February 7, 2024

**RE:** Atlas Tower 1, LLC Administrative Conditional Use Application (ACU-23-00003) – Response to Appellant Briefing Comments

SHEET TITLE:  
**SITE PLAN**

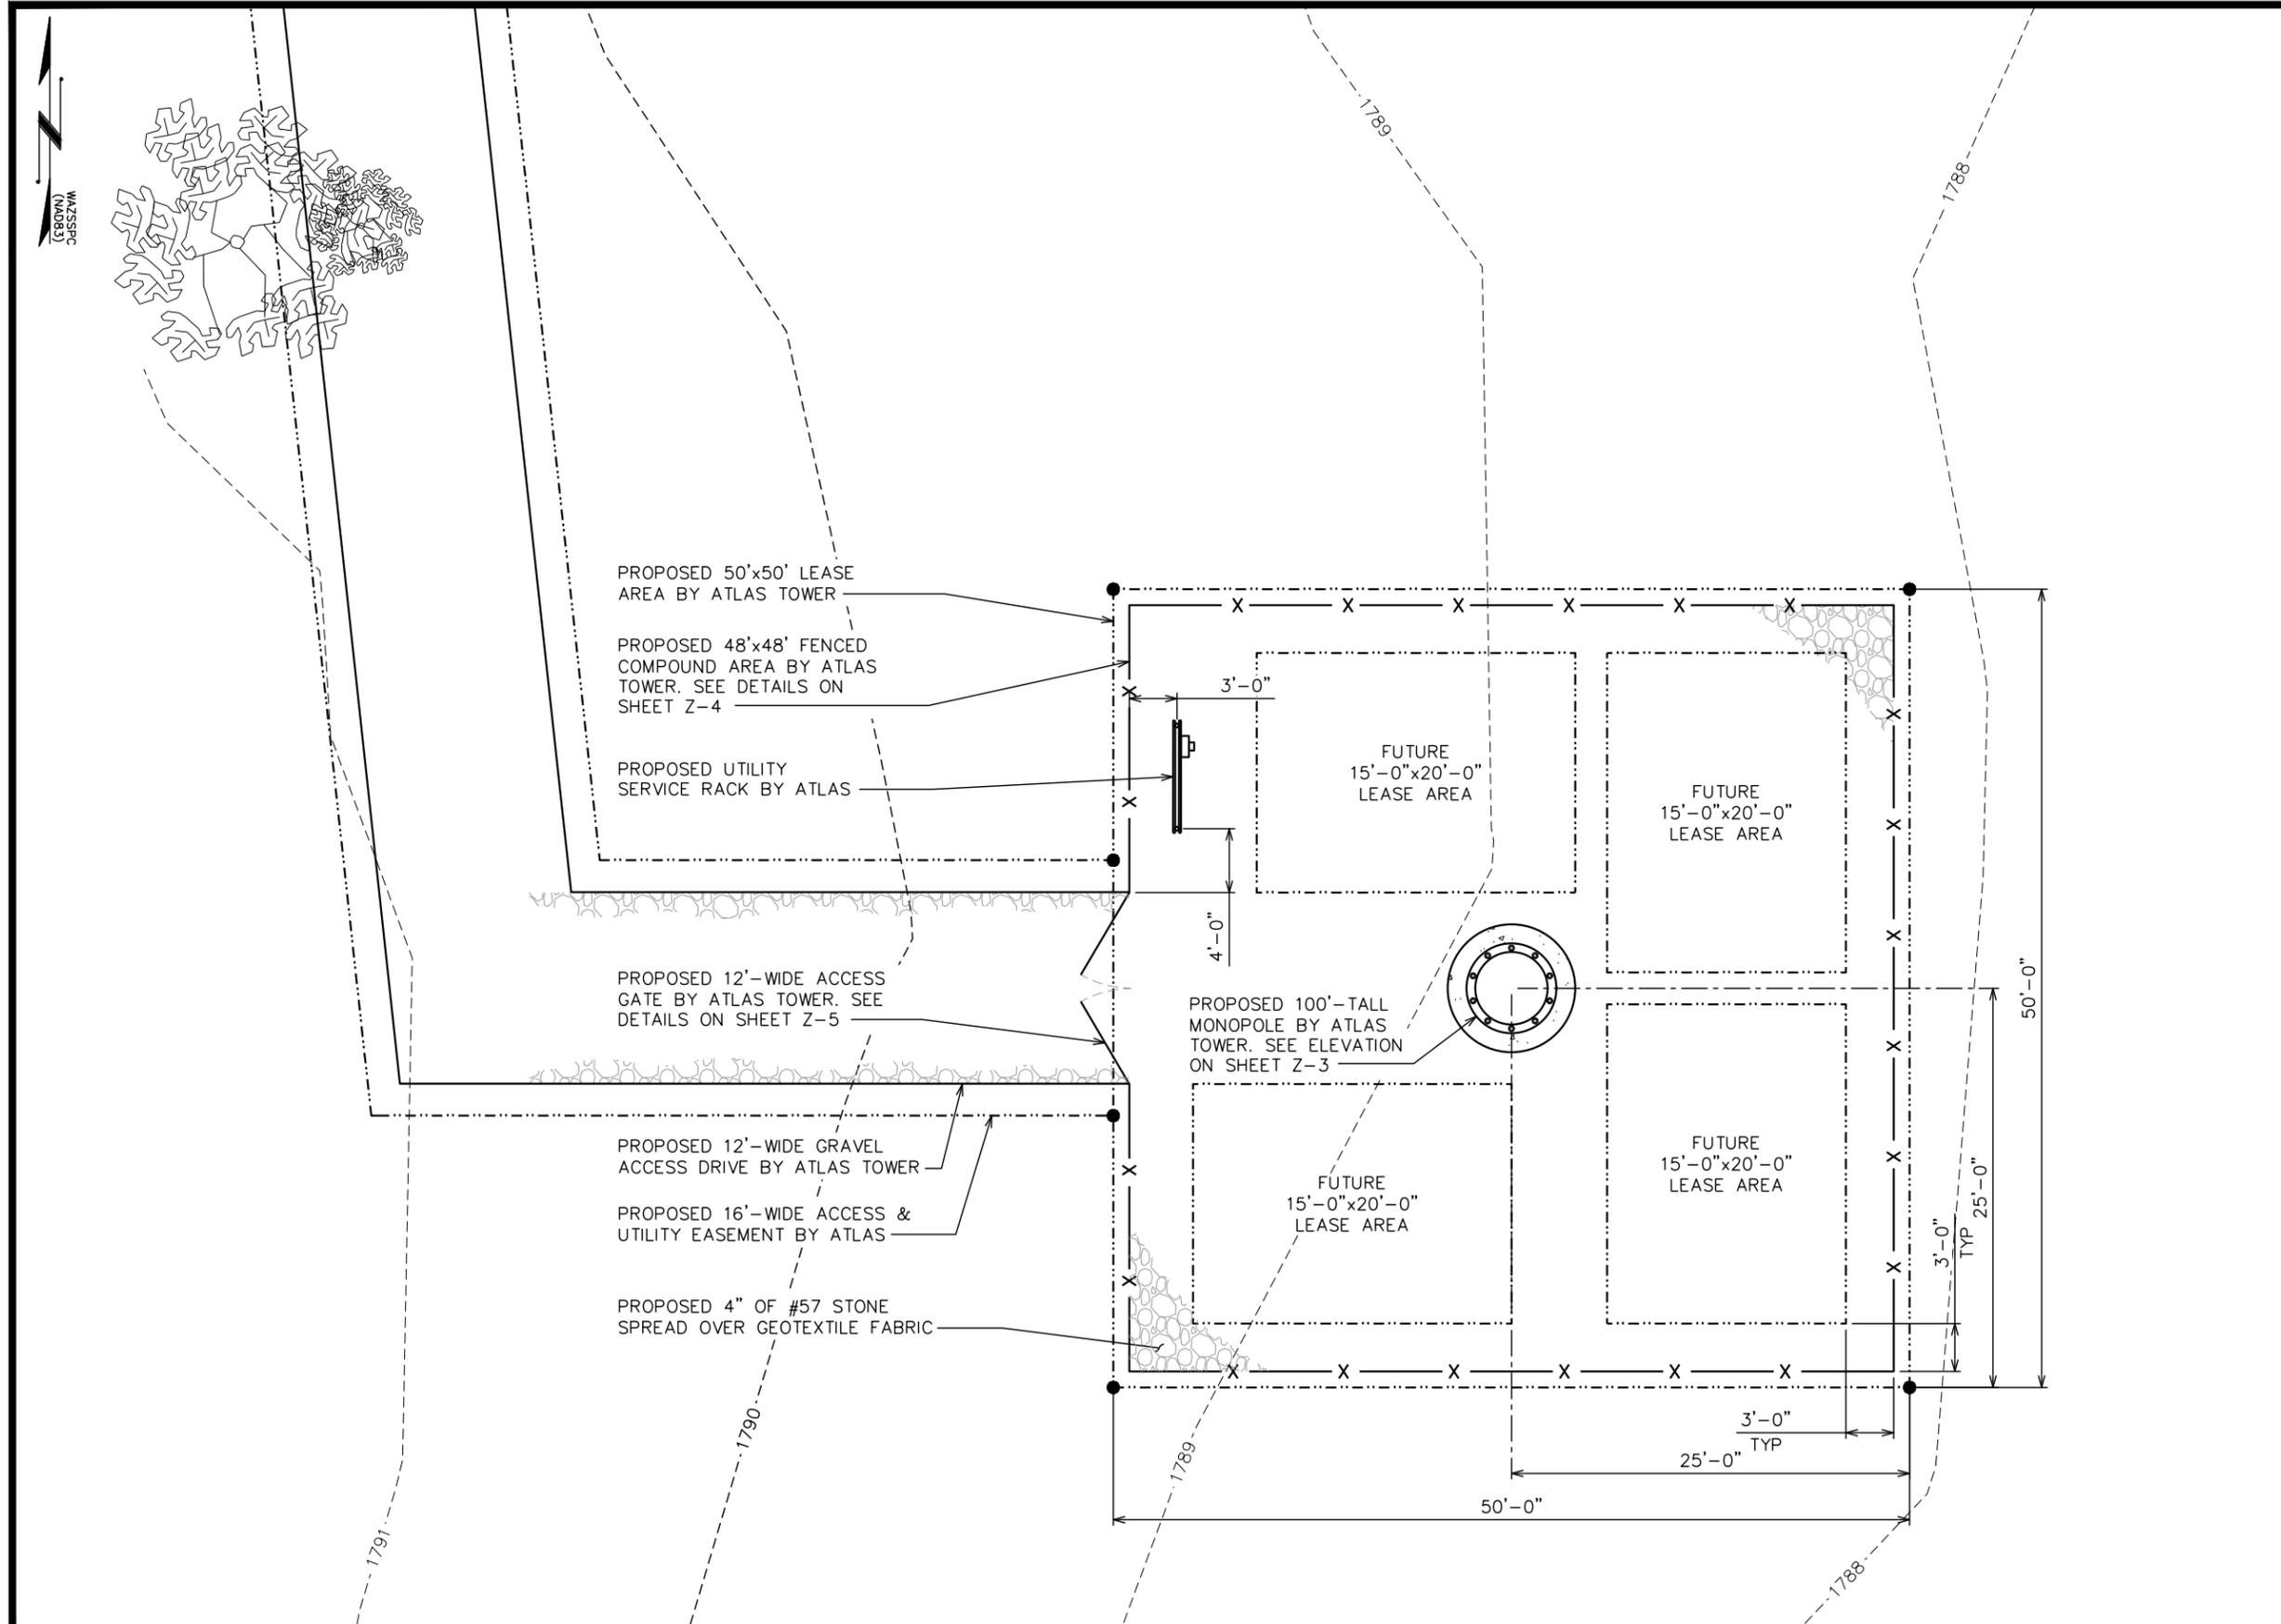
1. Page 21- broadband.map.fcc.gov and coverage is fine. Broadband is internet.
2. Page 22 – Kittitas asked if it was possible to move the tower to the west in effort to try and get it out of the neighbor’s direct sight. The county asked if we could move it maybe 20’. I talked to our construction manager and after looking at it all, we were able to determine that we could in fact move it 25’. We updated the design and submitted it. Revisions 1, 2, and 4 are irrelevant to this.

**Z-3**

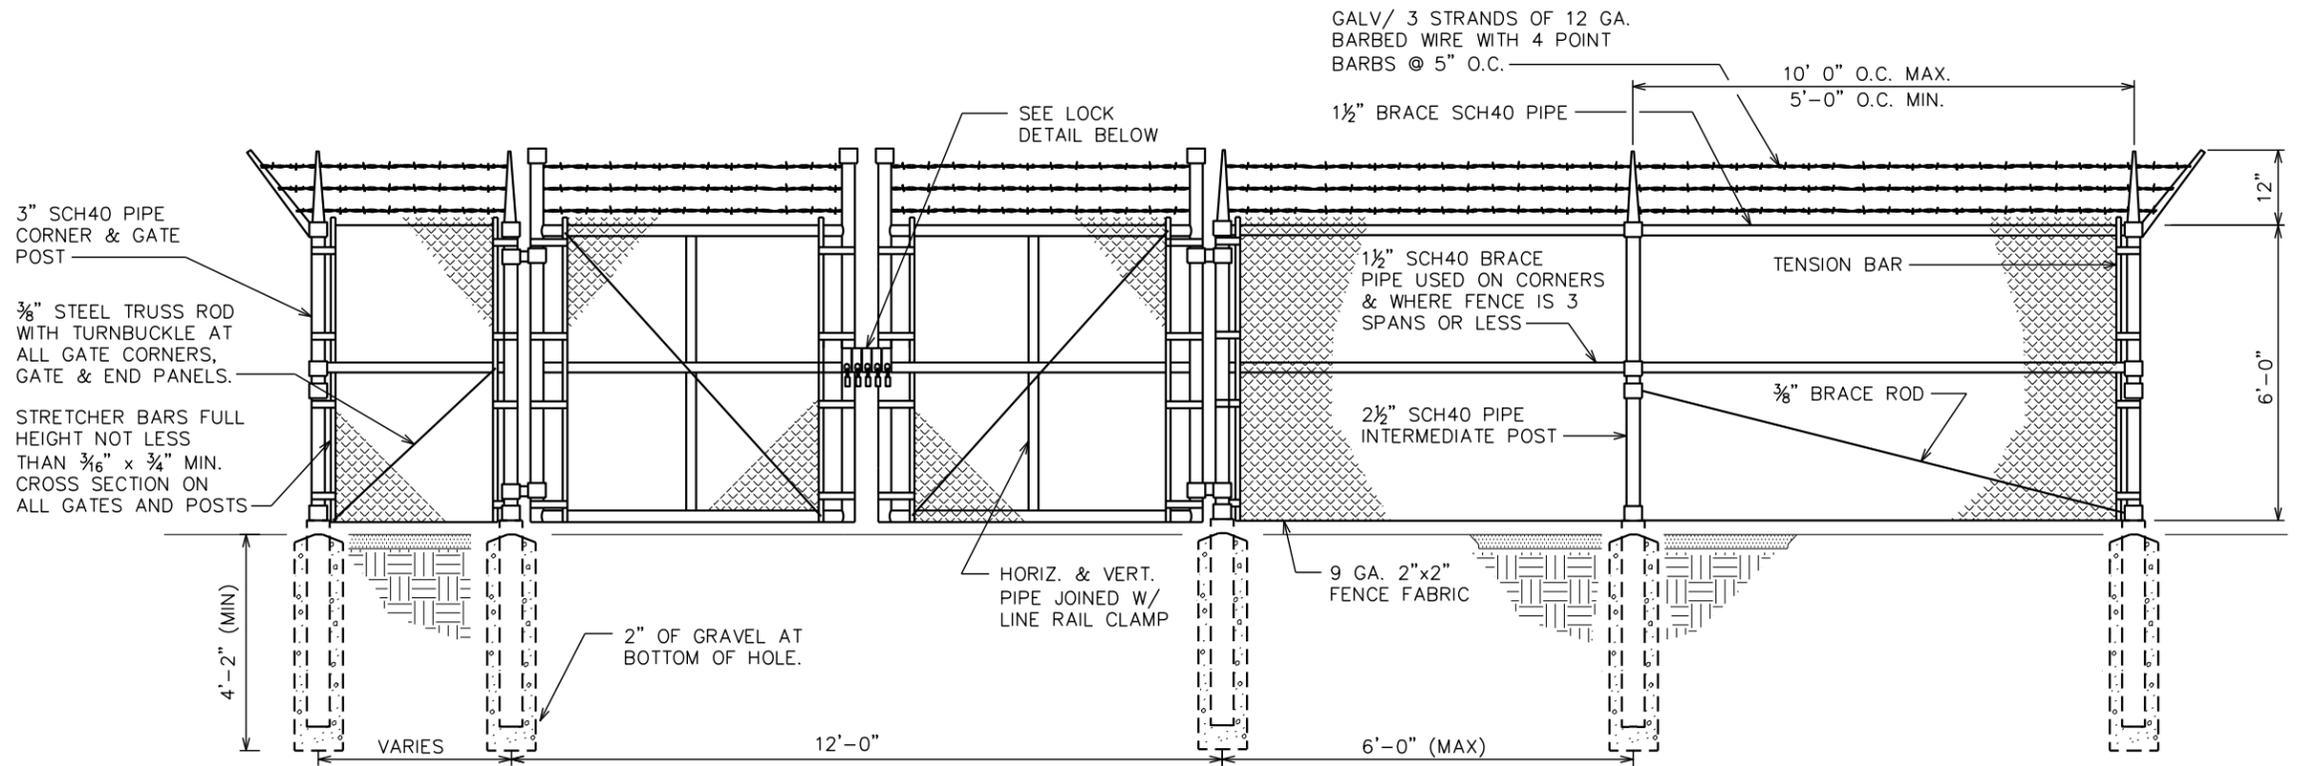
- c. Concerns with the visual aesthetics:
    - i. We will have our design updated to reflect the use of a compatible color to camouflage the tower. I have attached color swatches for you to review and choose which color is preferred.
